Letter of Intent Site Development Plan

D and D Management LLC
6485 Alibi Cr.
Colorado Springs, CO 80923
Project Name: Big O Tires

6985 N. Meridian Rd.
Peyton, CO 80831
Lot Size: 1.22 acres
Zoned – CC
Parcel number: 53124-01-008

10 SITE PLAN
SCALE: 1"=30'-0"

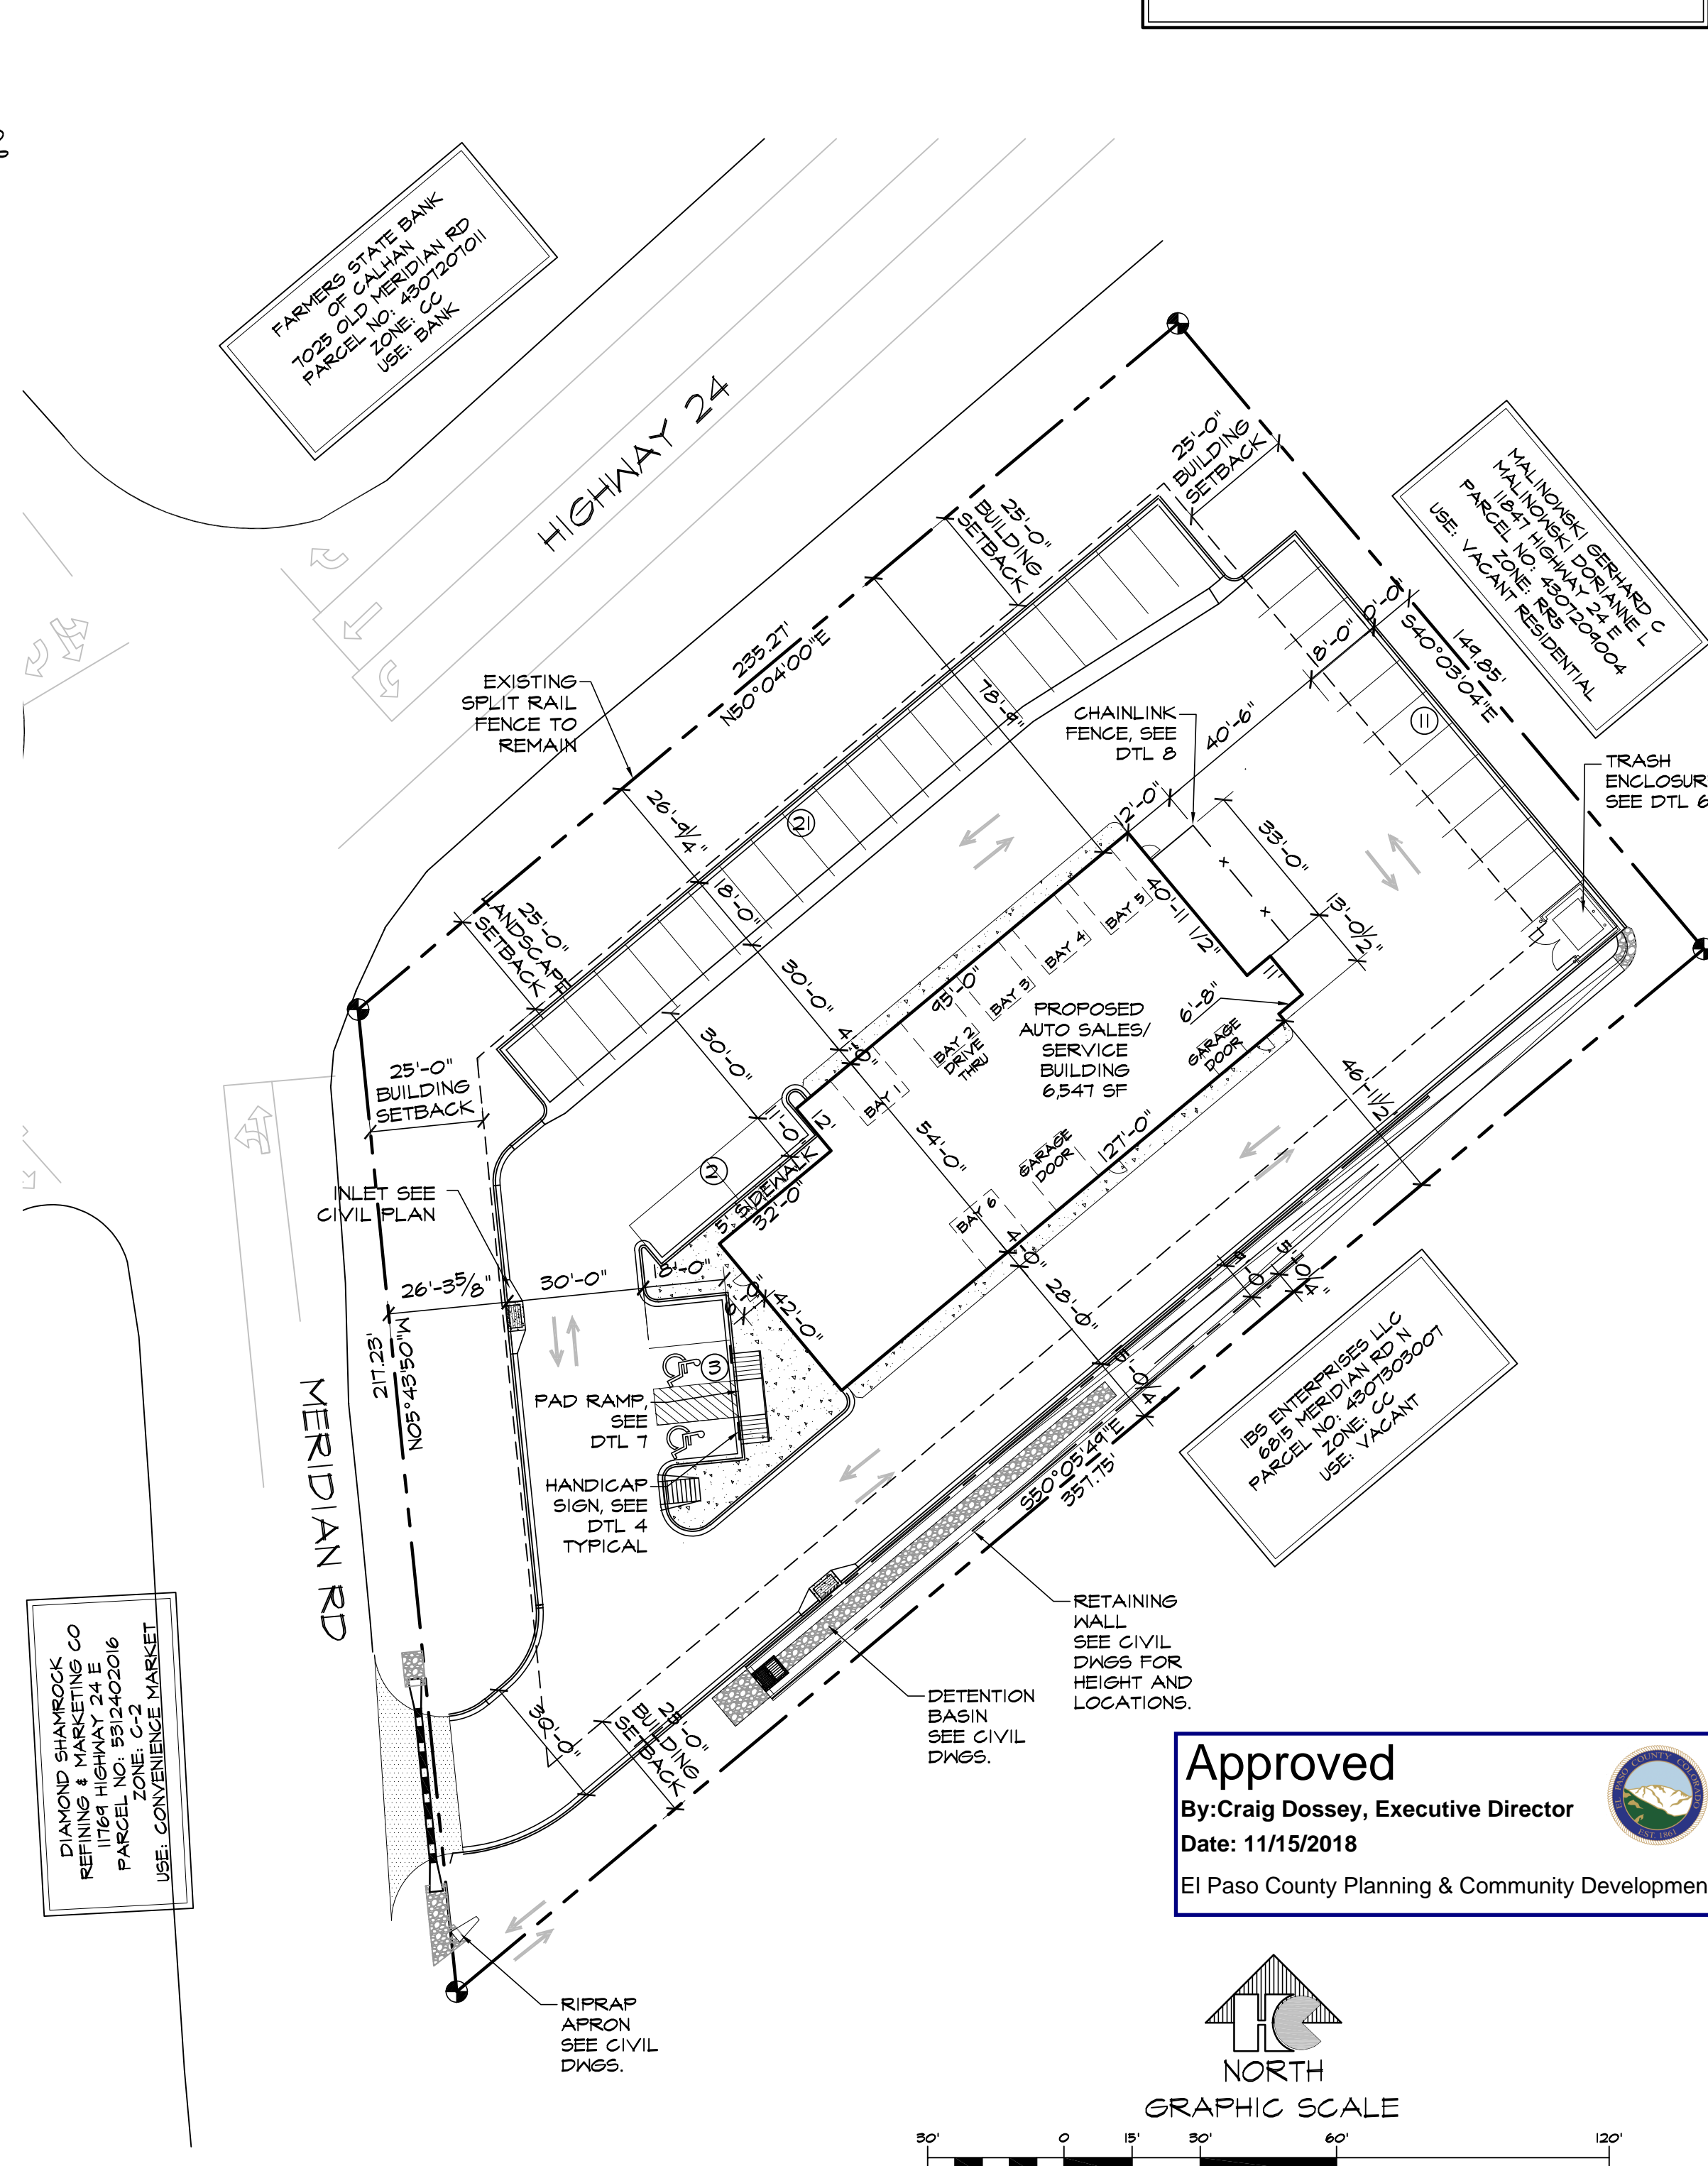
Include maximum employees for a shift to
calculate parking needs.
